Rezoning Transportation Analysis
Petition Number: Insert Zoning Petition #2021-161
General Location Identifier: 22902119

From: Brandon Brezeale, PE
Brandon.Brezeale@charlottenc.gov
704-432.5561

Reviewer: Walta Blackmon, PE
Walta.Brumskine@charlottenc.gov
704-432-1556

Revision Log:

NOT FOR CONSTRUCTION
Sheet Title:
Rezoning Site Plan

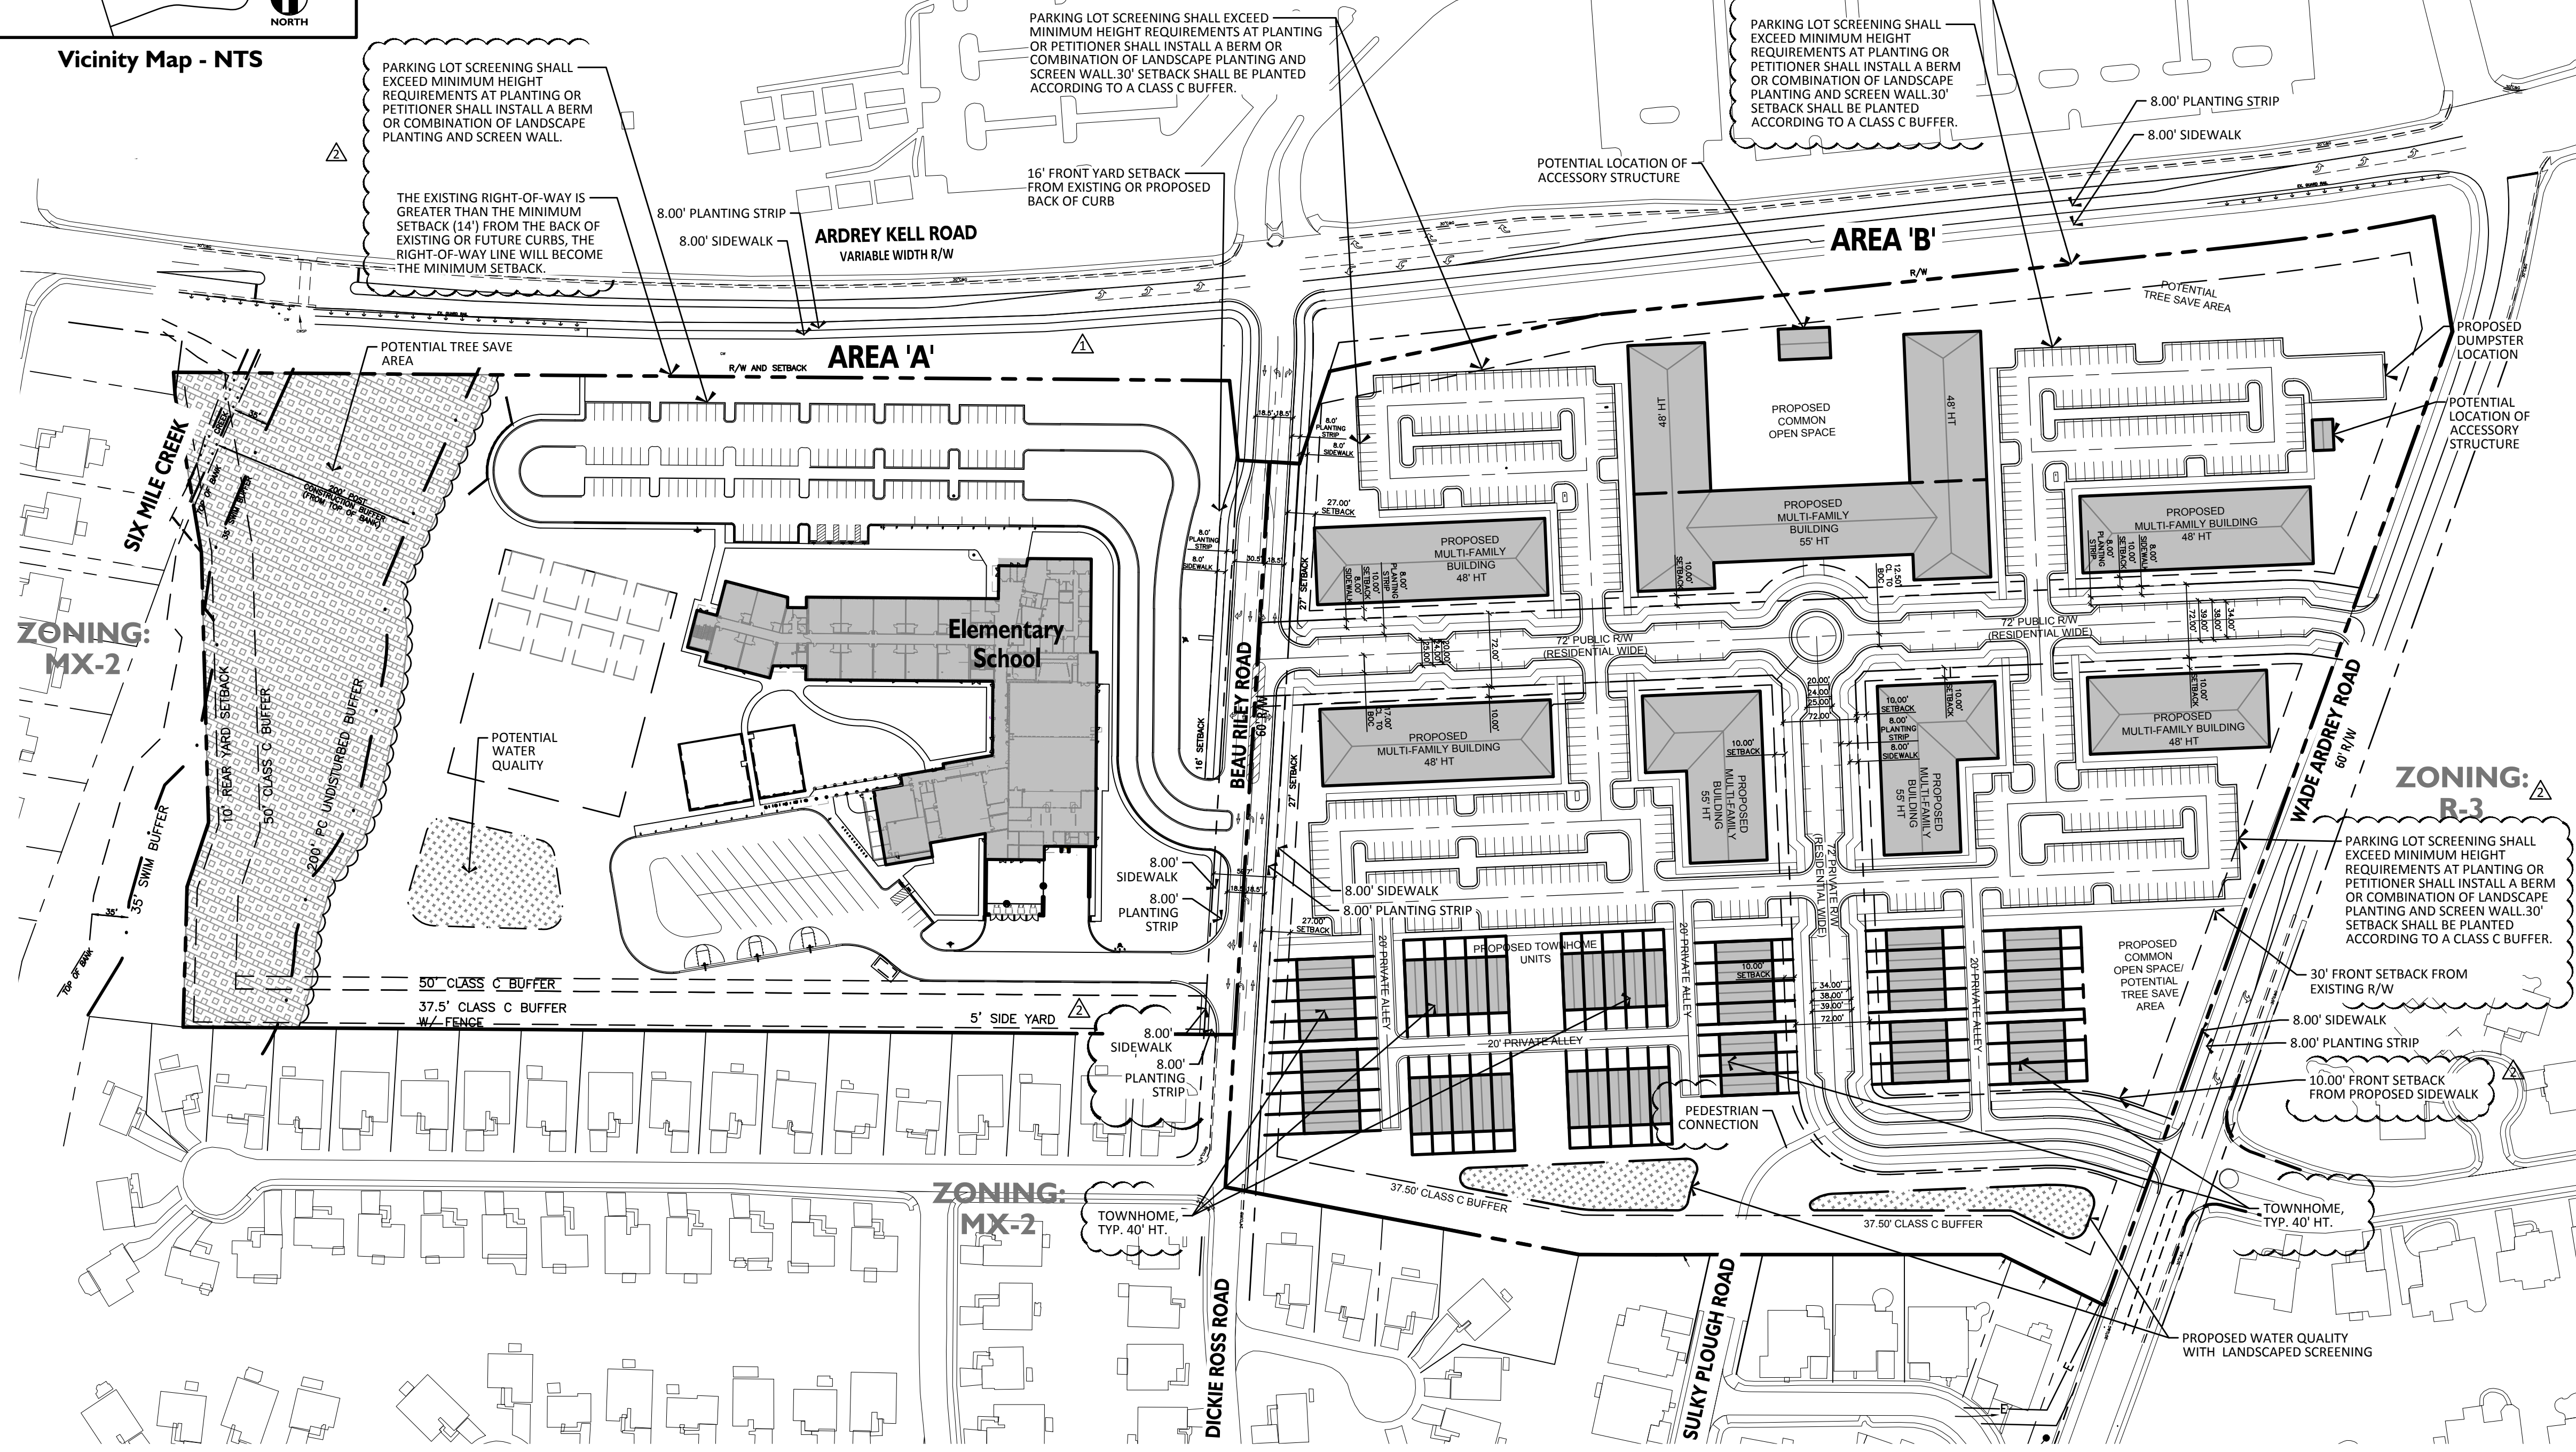
Clarifying Comment (site plan dated 10-11-2021): Charlotte BIKES policy requires bikes to be accommodated along Ardrey Kell Road. Provide a 12' Multi-Use path or show bike lanes existing on

plan. Online aerial mapping does not show bike lanes along Ardrey Kell in the vicinity of the project and CDOT prefers 8-foot planting strip and 12-foot multi-use path.

5. **Outstanding Comment** (site plan dated 10-11-2021): ~~Revise site plan and conditional note(s) to identify, depict, label, dimension, and itemize all proposed transportation-related infrastructure improvements.~~ The conditional notes should include commitments to fully construct and fund all TIS-recommended and ordinance-required transportation improvements with applicable phasing and funding sources identified.
6. ~~Add conditional note that all public transportation improvements will be constructed and funded by the residential development before the residential site's first building certificate of occupancy is issued.~~
